Sydney Metro Design
Review Panel
Letter of Design Excellence Pitt
Street South Over Station
Development

Pitt Street North Over Station Development – Design Excellence

Sydney Metro Design Review Panel

Advice and Actions Record – 14-15 September 2020

1.1 Shadow Analysis  
Solar Access to Hyde Park

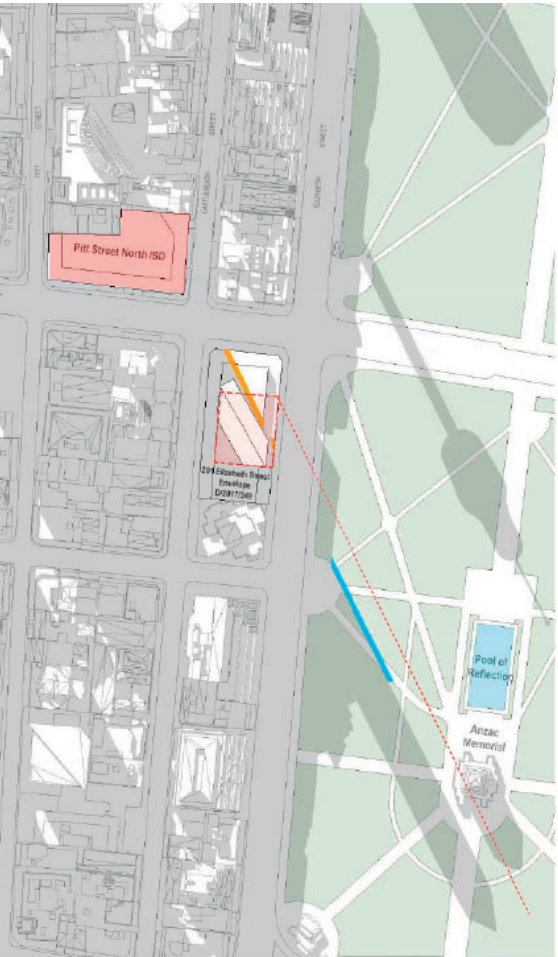
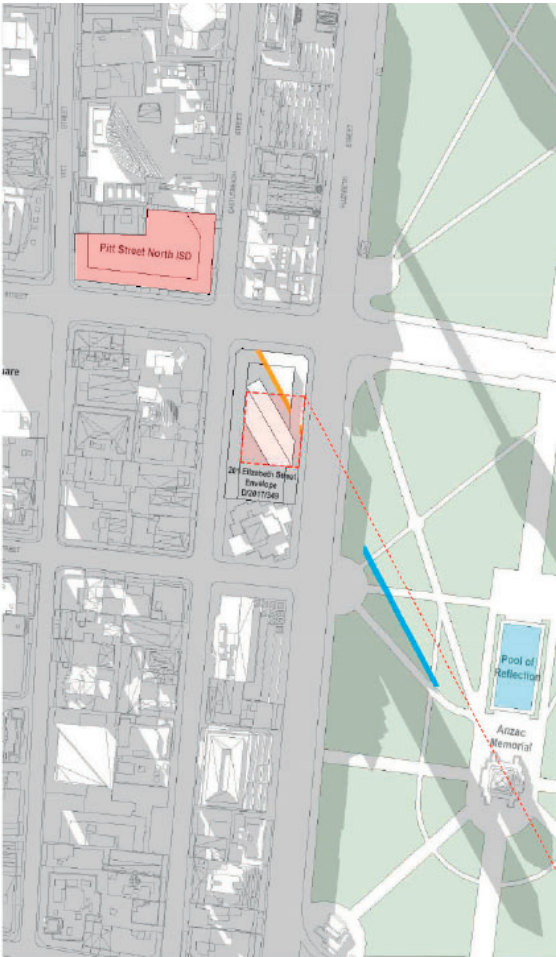
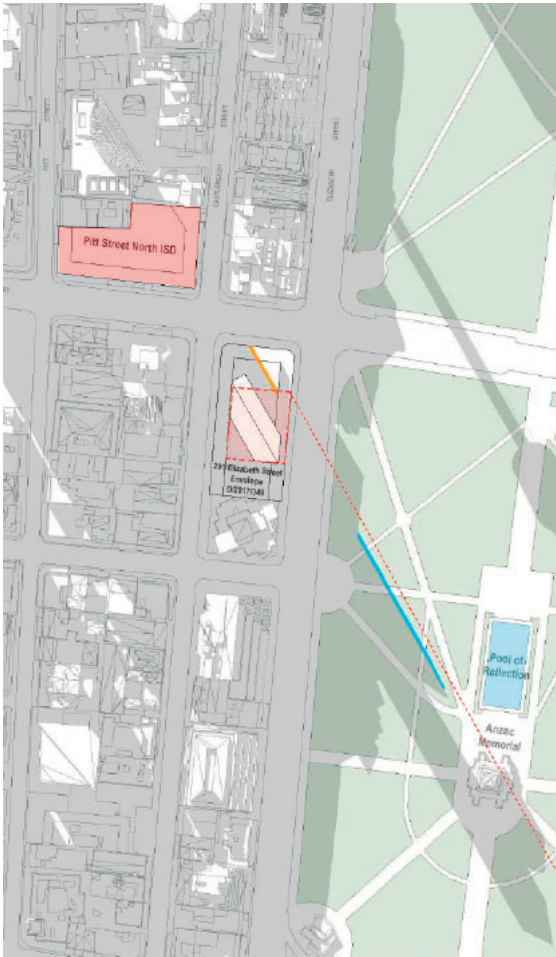
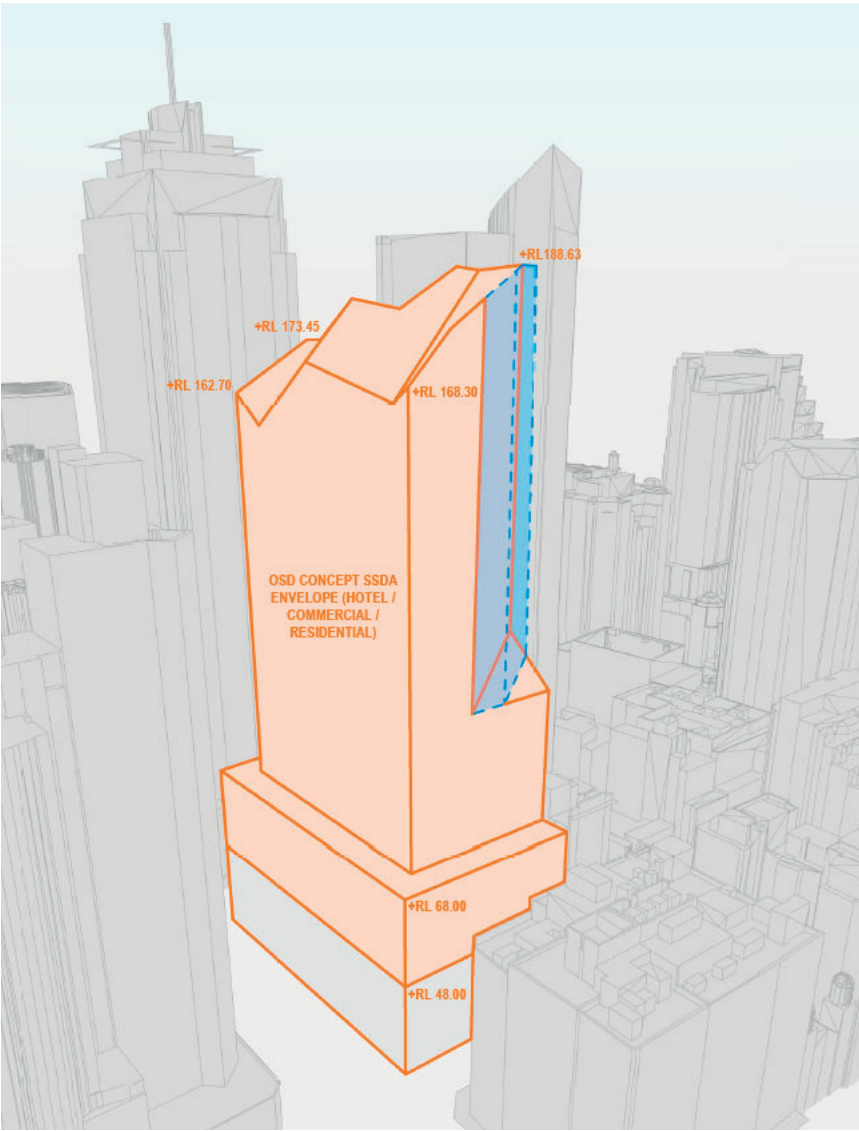
- The Panel notes the shadows cast over Hyde Park by the Pitt Street development remain within the footprint of shadow already cast by existing development at 201 Elizabeth Street and an alternative and smaller built form envelope proposed for 201 Elizabeth St (which is currently not intended to proceed).
- The Panel defers to DPIE for compliance decisions relating to overshadowing of surrounding residences.

Effective Glazing & Facade treatments (Tower)

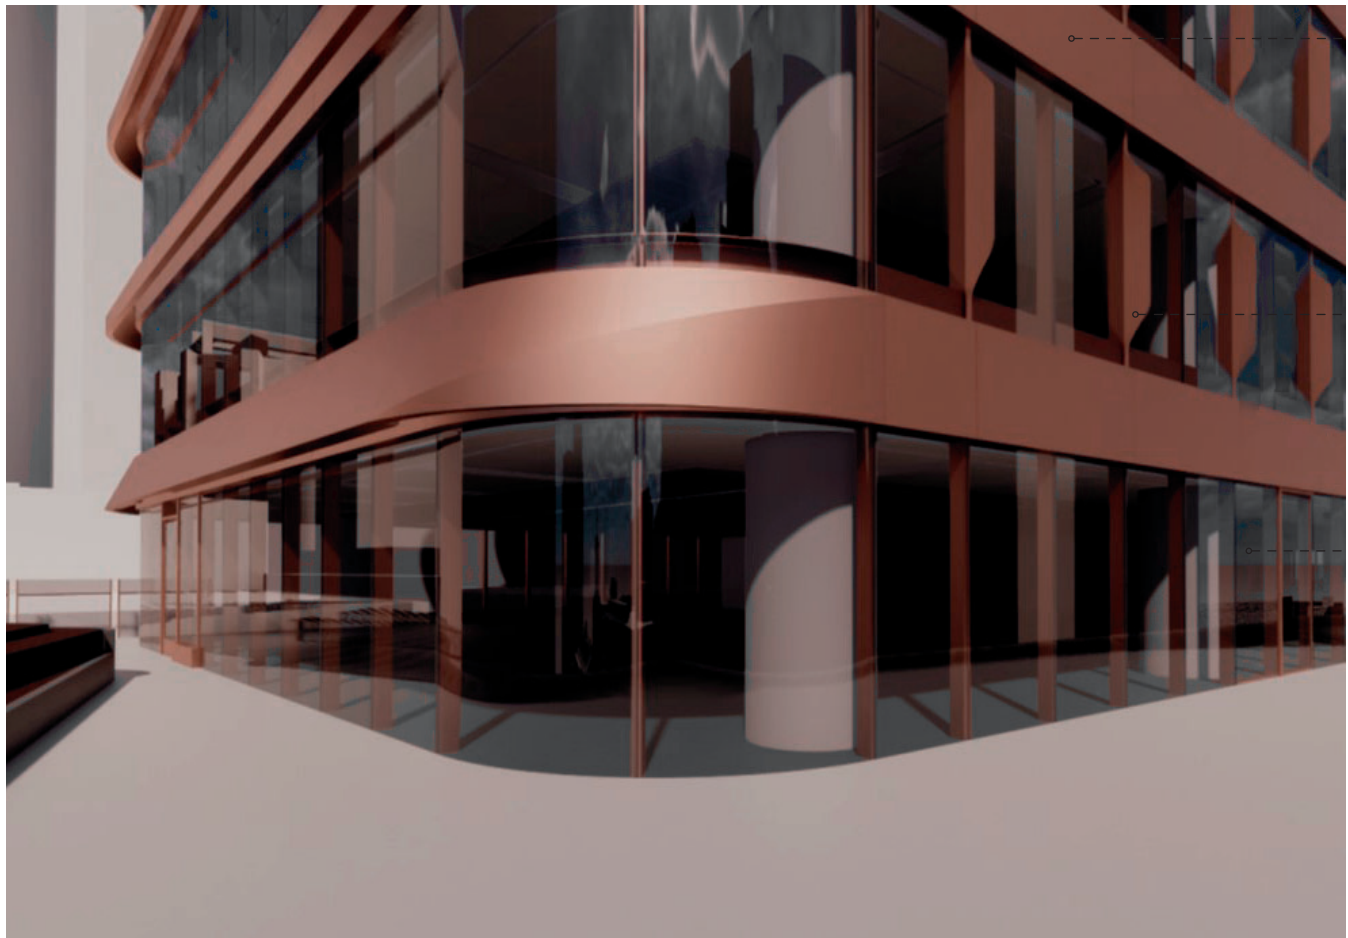
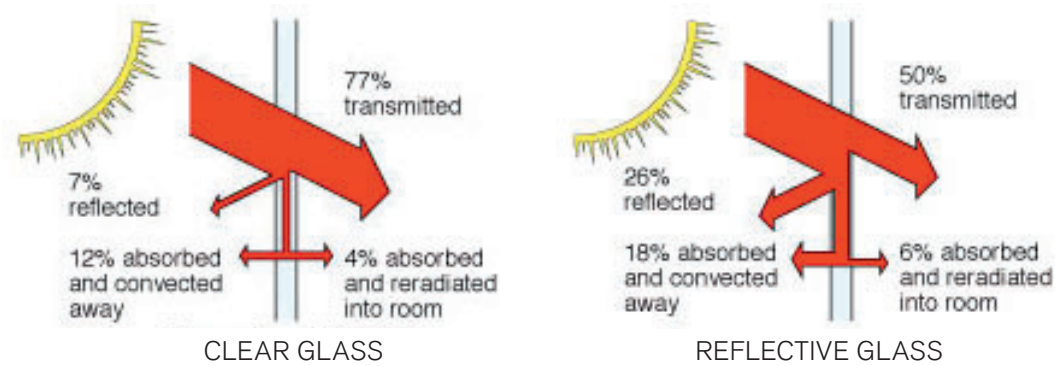
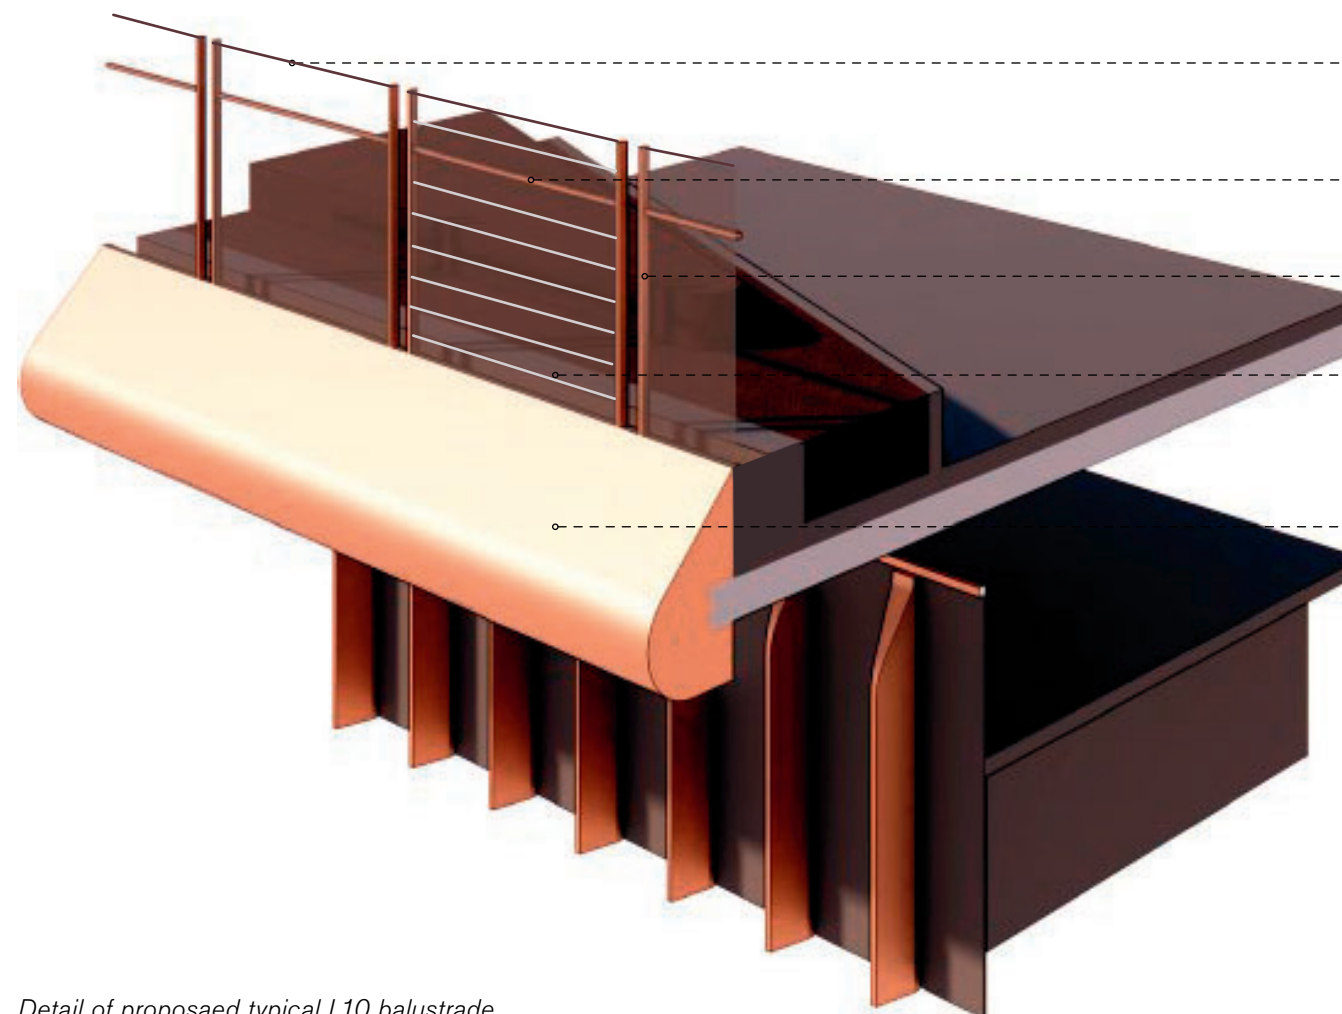
- The Panel supports the measures taken to minimise reflectivity to protect Powerful Owls and other birds from flying into the building facade glazing and balustrades.
